<b>Application Ref:</b>	3/2021/0290	 <b>Ribble Valley Borough Council</b> <a href="http://www.ribblevalley.gov.uk">www.ribblevalley.gov.uk</a>	
<b>Date Inspected:</b>	31/3/2021		
<b>Officer:</b>	BT		
<b>DELEGATED ITEM FILE REPORT:</b>		<b>Decision</b>	Approval

<b>Development Description:</b>	Demolition of existing conservatory and erection of timber clad extension on the same footprint. Amendment to existing rear window. Raising of existing extension roof by 800mm and application of render to existing elevation.
<b>Site Address/Location:</b>	47 Ramsgreave Road, Ramsgreave, Blackburn. BB1 9BH

Drawing Title
PROPOSED ELEVATIONS

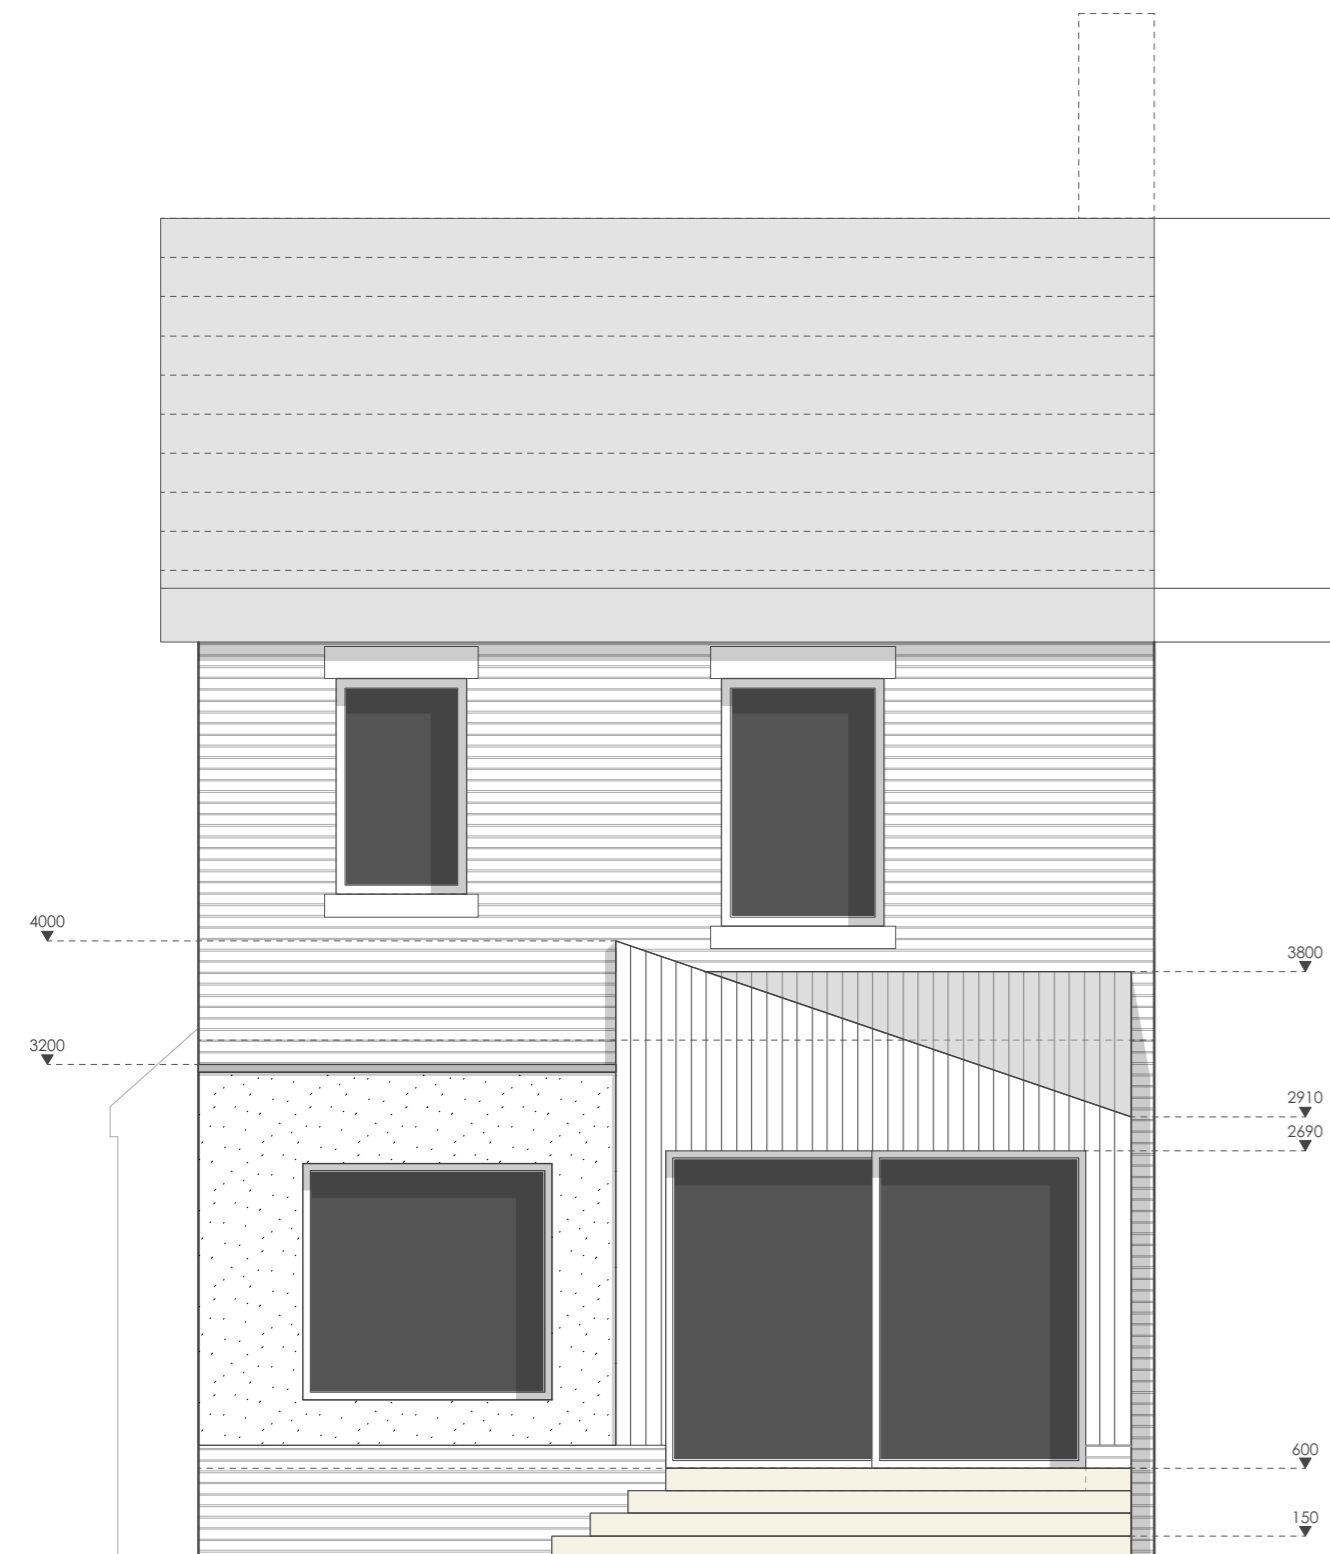
The proposed extension will incorporate a set of sliding doors and a window on its rear South-east elevation. These windows will solely allow views into the property's rear garden therefore it is not considered that the proposed windows will have any adverse effects upon existing levels of privacy.

The proposed works also include a set of patio steps which will be adjoined to the rear elevation of the extension which will replace the steps adjoined to the property's existing conservatory. The new steps will not exceed the height of the existing steps therefore it is not considered that the proposed works would offer any new opportunities for overlooking.

The proposed extension will incorporate a butterfly style roof which will be 0.8 metres higher than the property's existing conservatory roof at its highest point. The proposed increase in roof height may lead to some minor overshadowing however the extension's inverted roof slopes will be situated directly adjacent to the neighbouring conservatory which will largely reduce any potential overshadowing effects.

Moreover, the extension will not be an over dominant feature in as much that it will be built on the footprint of the property's existing conservatory with an eaves and roof height of 4 and 2.9 metres respectively making it wholly subservient to the primary dwelling and within the realm of permitted development.

PROPOSED SITE PLAN
1:200@A3

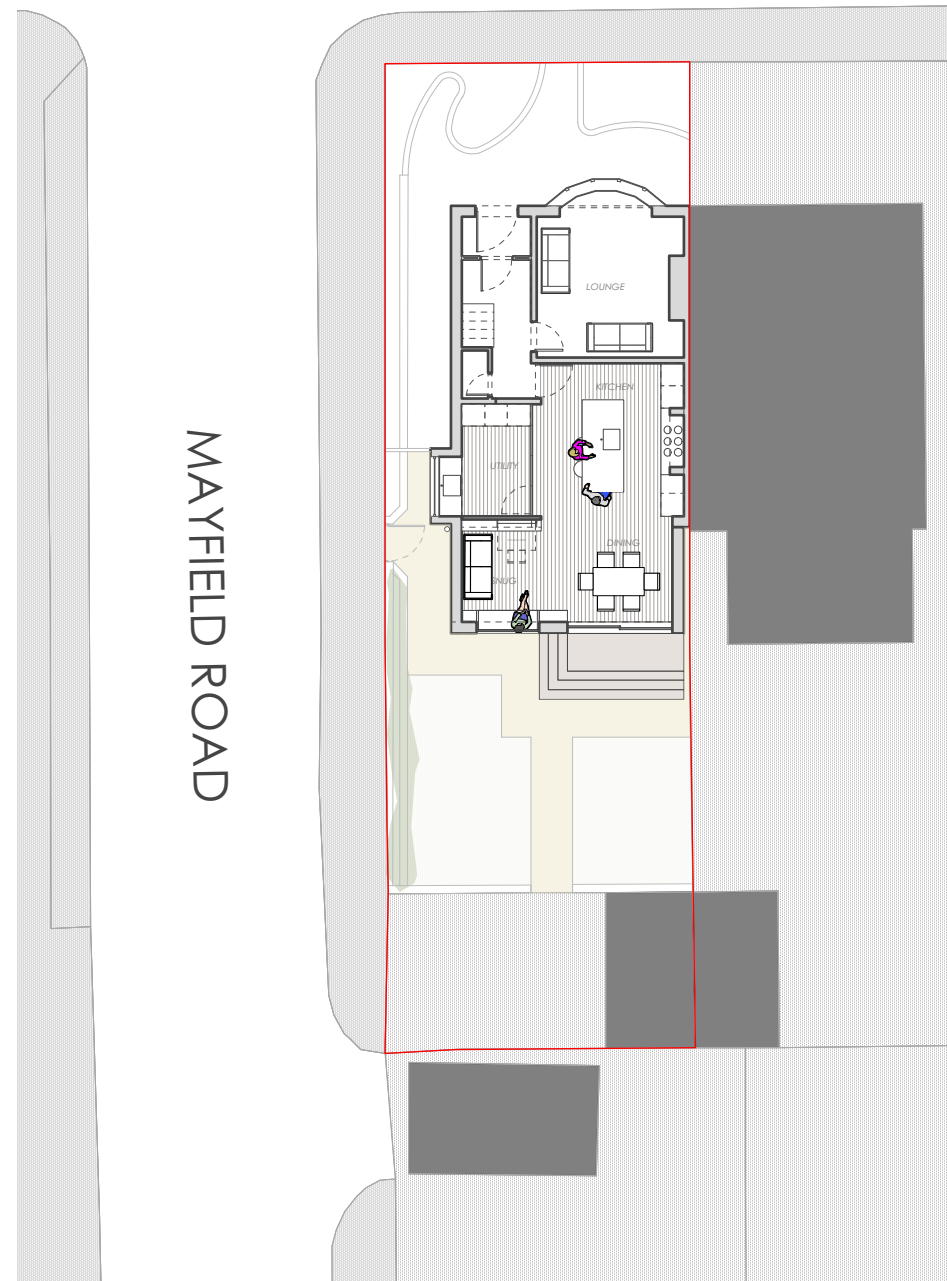
The proposed extension will be sited on the footprint of the property's existing conservatory which is situated directly adjacent to the conservatory of the neighbouring property of No. 45 Ramsgreave Road. The aforementioned conservatories are almost identical in terms of their outwards projection therefore the siting of the proposed extension will not lead to any undue impact upon natural light or outlook for the residents of No. 45 Ramsgreave Road.
